**RE: CONCEPT DEVELOPMENT APPLICATION (STAGED DEVELOPMENT) FOR
ALTERATIONS AND ADDITIONS (SSD 7693)
MULPHA AUSTRALIA LTD, INTERCONTINENTAL HOTEL**

I am a resident of The Astor apartment building, which is located at 123-125 Macquarie Street, in the block adjacent to the proposed development site. I strongly object to this proposal due to the following considerations:

SETBACK DIAGRAM | VIEW FROM NORTH-EAST

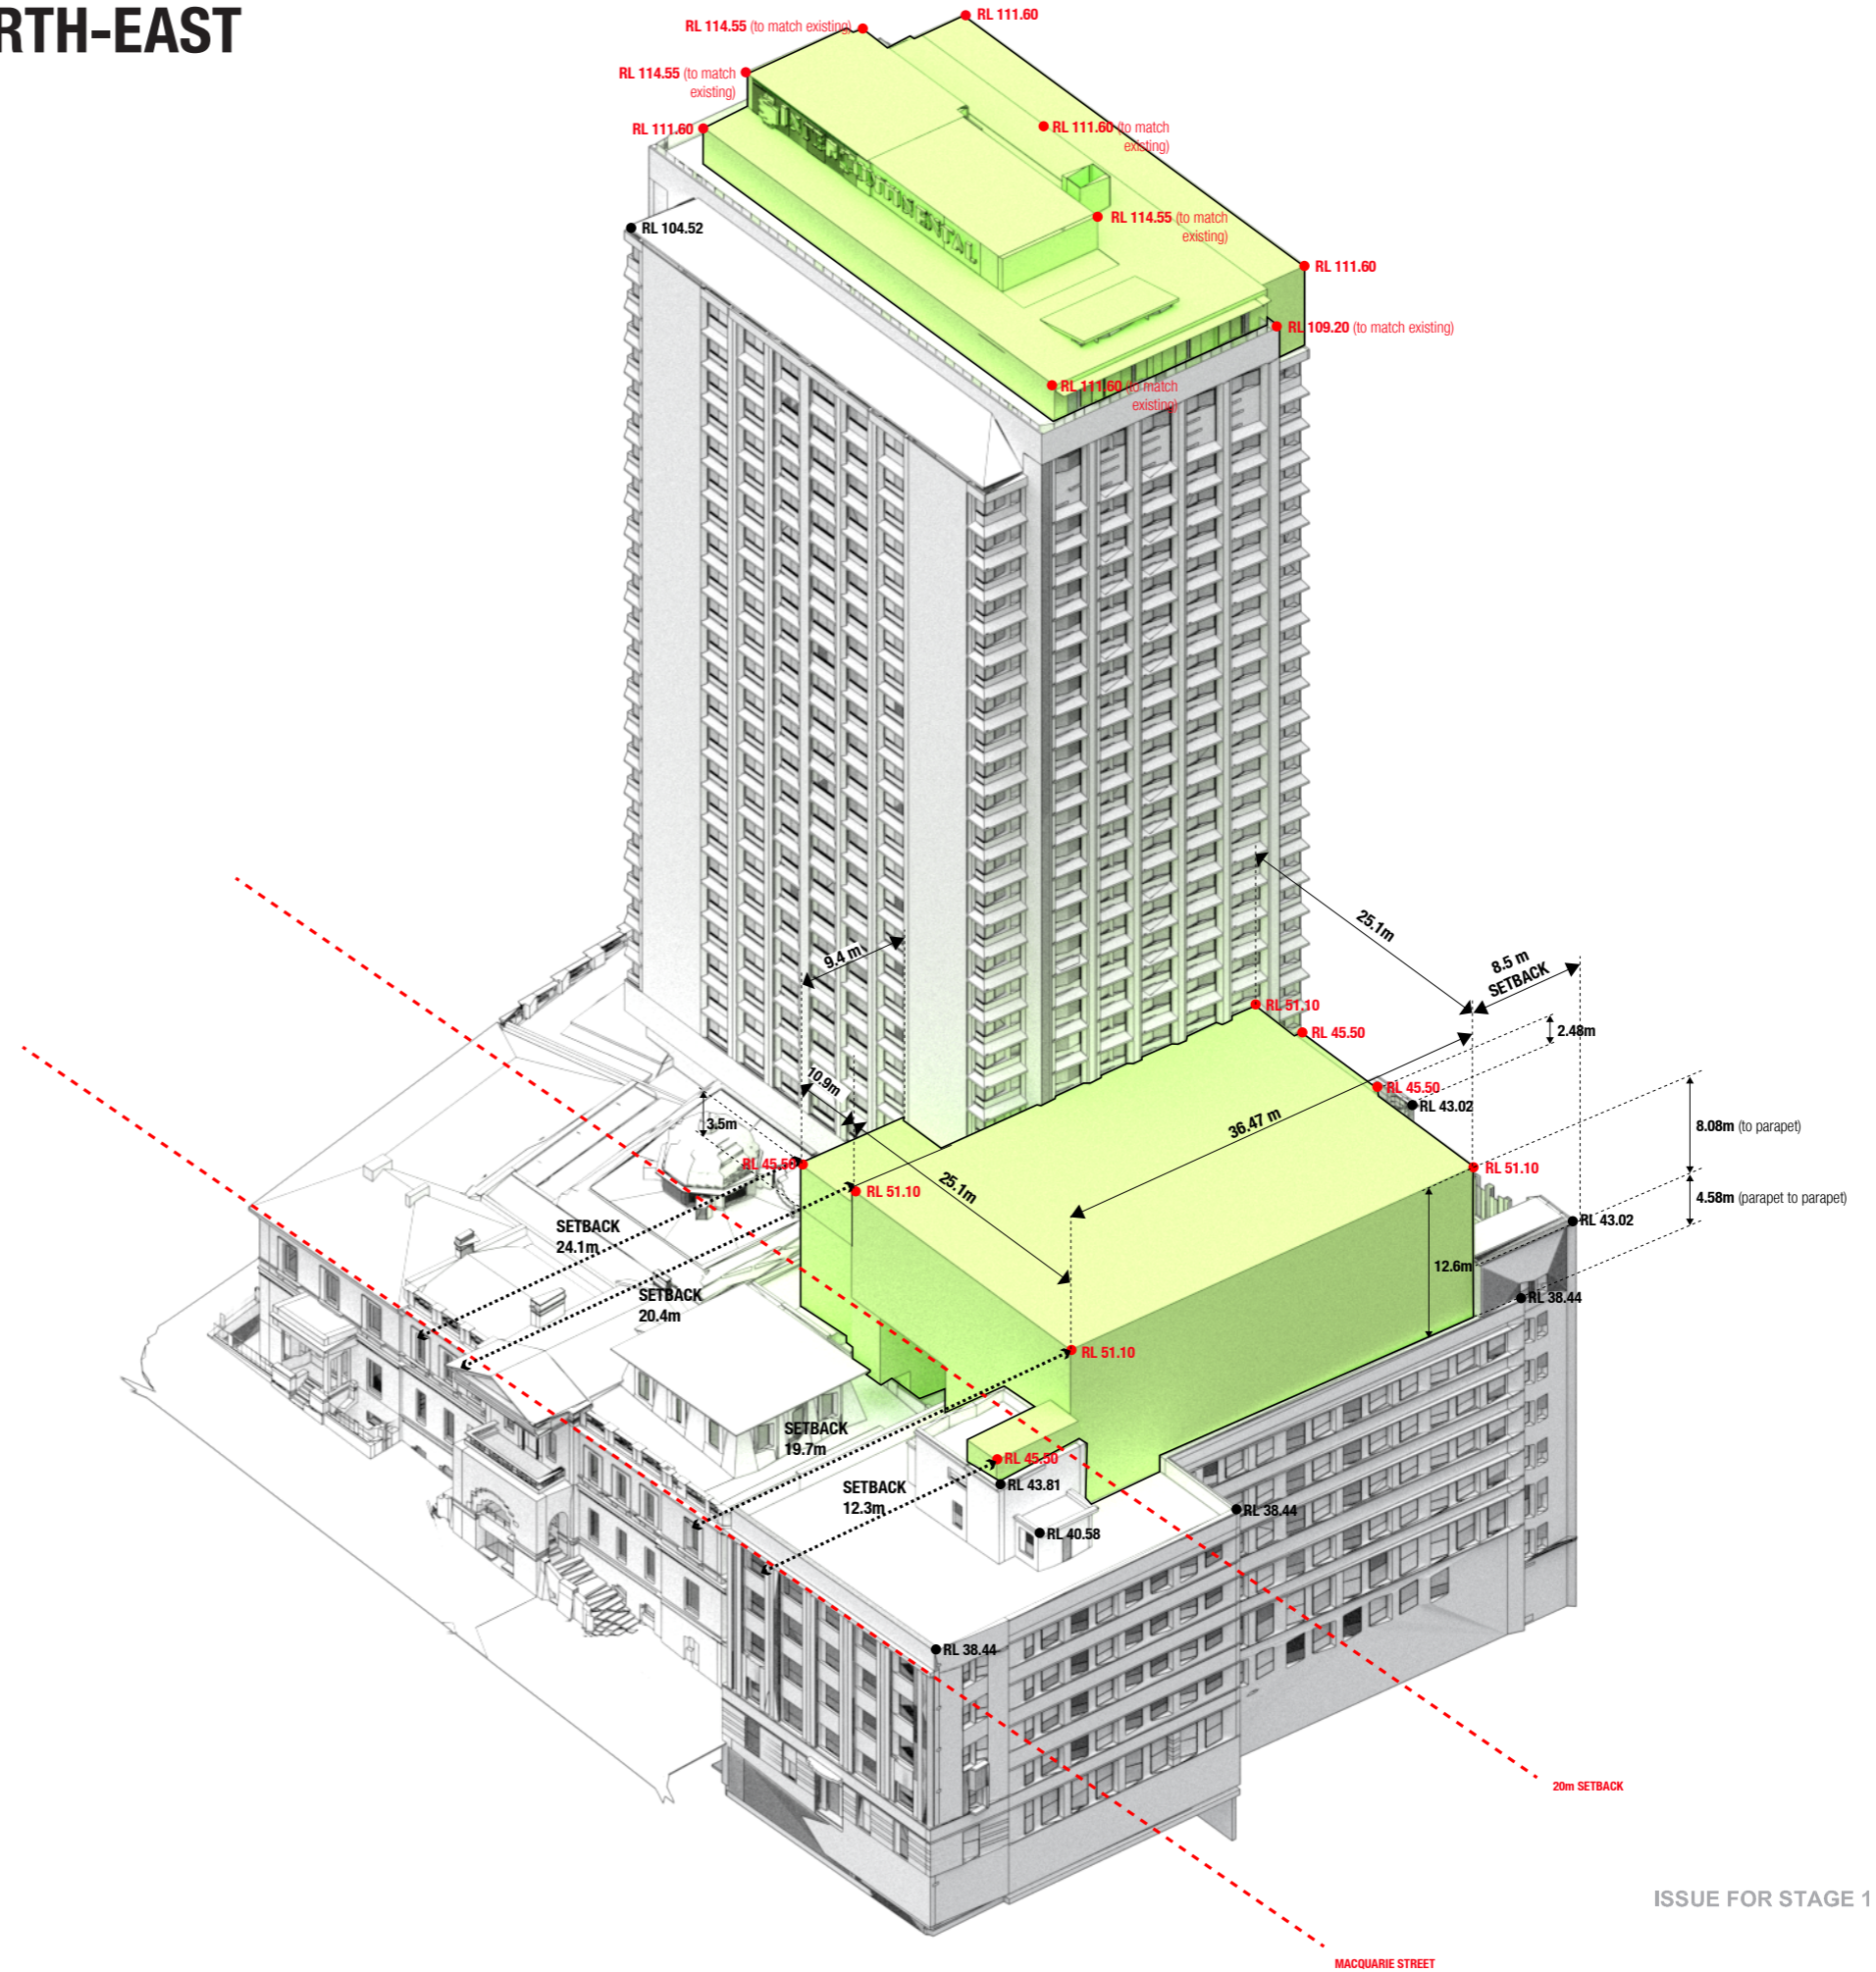
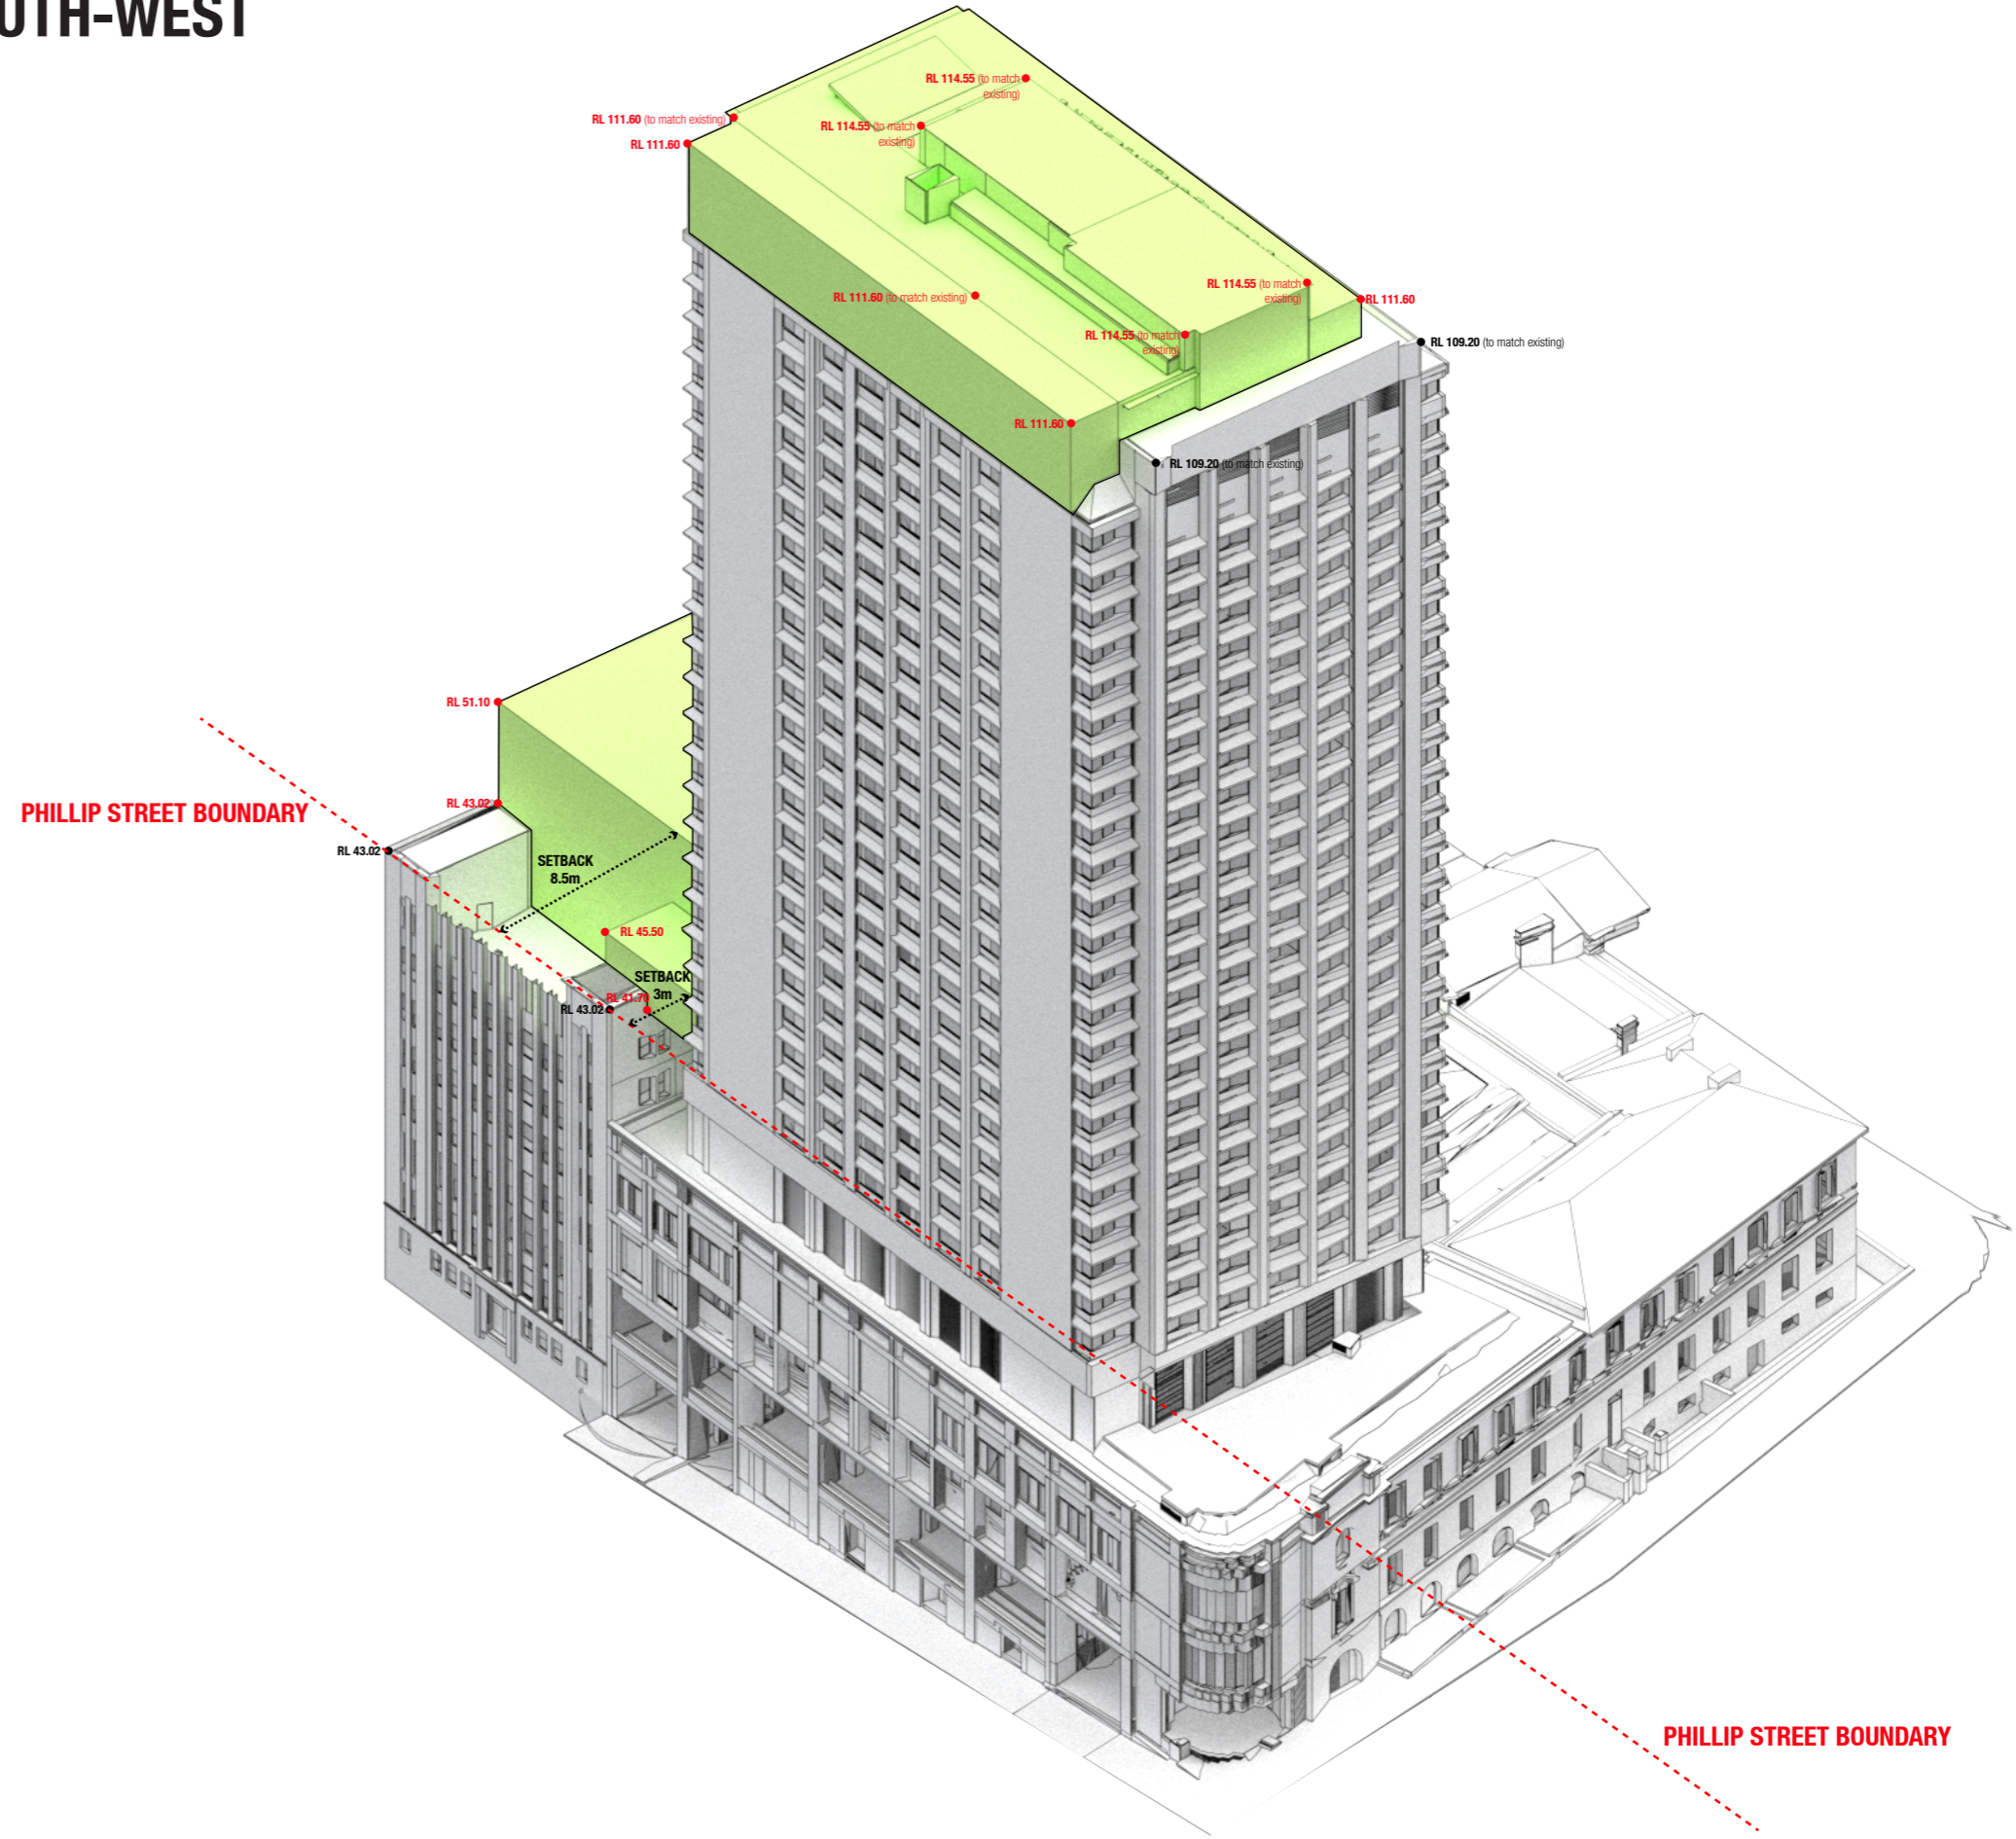
1. Central Sydney Development Control Plan 2012 (DCP 2012) defines the northern end of Macquarie Street as the “Macquarie St Special Character Area”:
 - a. It contemplates a consistent height and alignment of street wall buildings, with taller towers set back 30 metres, in order not to impact on the scale of Macquarie Street, and to emphasise the edge of the city. SSD 7693 provides a building envelope with a setback of only 10 metres.

- c. The impact only occurs because the proposal does not comply with the requirement of DCP 2012 for a 30 metre setback, and while there are no public benefits from this breach, there is indeed a public disbenefit in terms of heritage impacts.
